Site Plan Drawing_v1.pdf Markup Summary

DRAWING: Mountain View MAIN ID

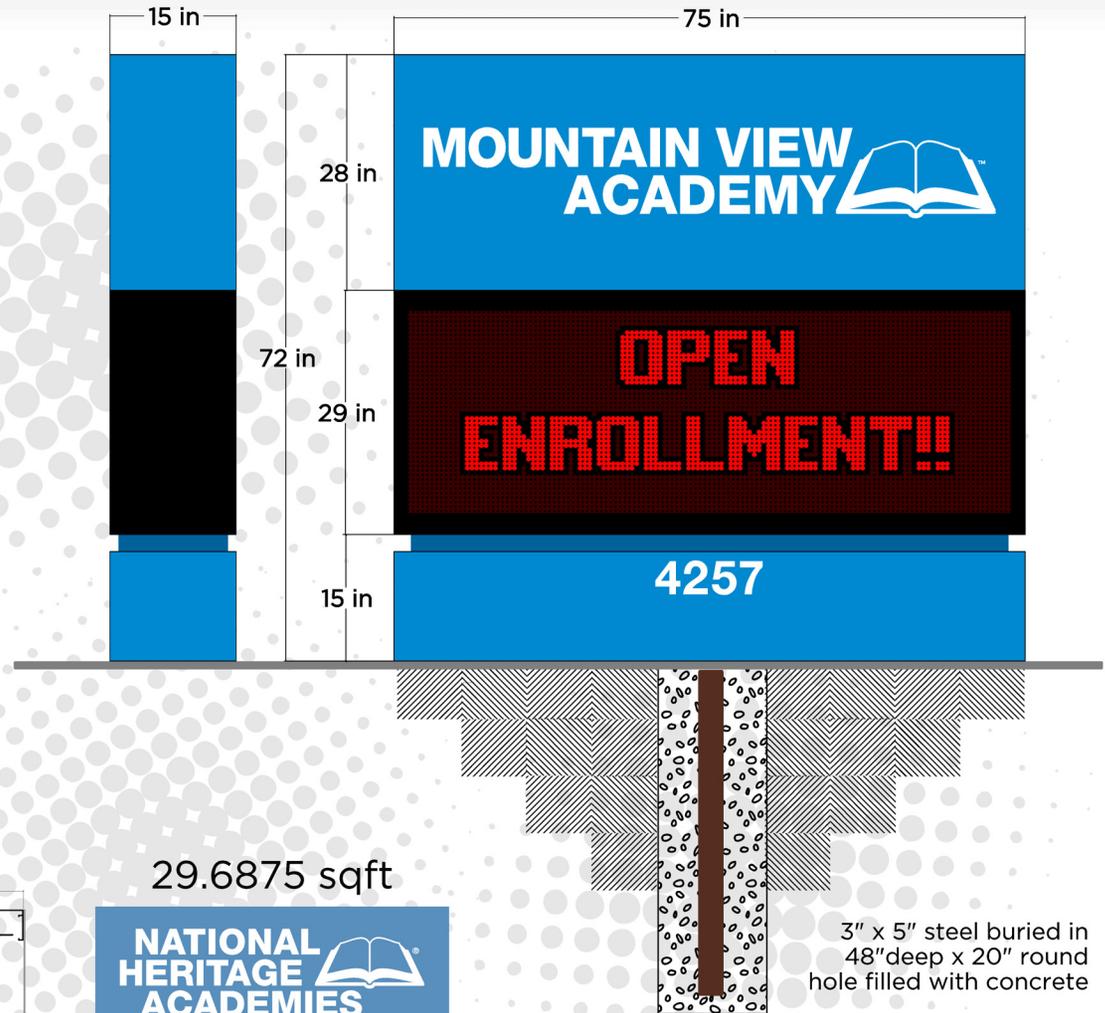
Please provide clear site plan showing exact distances from lot line. Based on the scale of the plan, it appears that the sign is setback 25 feet from the property line. Please revise plan to show scaled dimensions clearly.
